A14
**Cambridge to Huntingdon
improvement scheme**
Development Consent Order Application

Response to ExA's Second Written Questions:

Principal Issue 13 Water Issues

August 2015

from the Great Ouse. All Scenarios use the same tailwater condition.

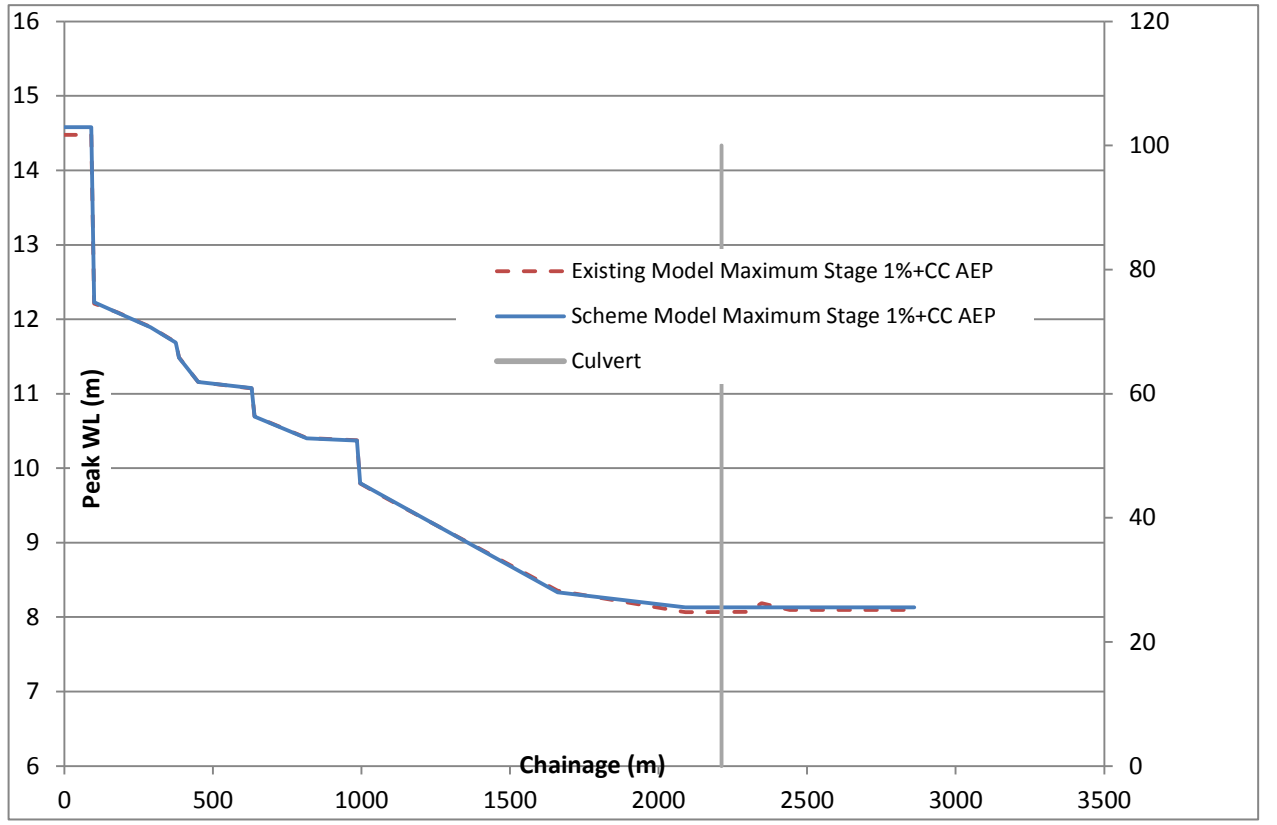
As the 2001 flood event has been said to be the result of blocked culverts and insufficient maintenance, would the scheme increase the number of culverts on the eastern Award Drain? If so, how would the maintenance of the additional culverts be regulated. (REP2-014, para3)

1. The scheme would require the construction of three additional culverts on the Hilton Drain, referred to in section 11 of the *Flood Risk Assessment* (Applicant reference 6.3, Appendix 17.01, PINS reference APP-744) as the Eastern Award Drain. One of the culverts would convey the Drain under the new A14 mainline. Two additional short culverts would be required to convey the Drain under access tracks. These culverts are shown on *General Arrangement Sheet 11* (Applicant reference HE/A14/EX/11 PINS reference APP-774).

2. Maintenance of Highways England's operational assets in the region of the scheme is currently managed under a system of Asset Maintenance and Operational Requirements (AMOR) which are secured under contract with the asset support contractor. This is an outcome focussed approach to maintenance of drainage and other assets which seeks to match the maintenance supplied to the maintenance needs, including the sensitivity of a location to flooding, of any given asset. This accords with industry led sector guidance published as part of the Highways Maintenance Efficiency Programme. Contractor performance against the AMOR is kept under review and sanctions apply for poor performance.

3. As an ordinary watercourse the local drainage authority, Huntingdonshire District Council (HDC), is responsible for the regulation of the proper flow of water through the Eastern Award Drain in accordance with the Land Drainage Act 1991. As such HDC has powers (pursuant to section 25A) to require persons in control of the watercourse to remedy any impediment to the flow of water and these powers would not be affected by the DCO.
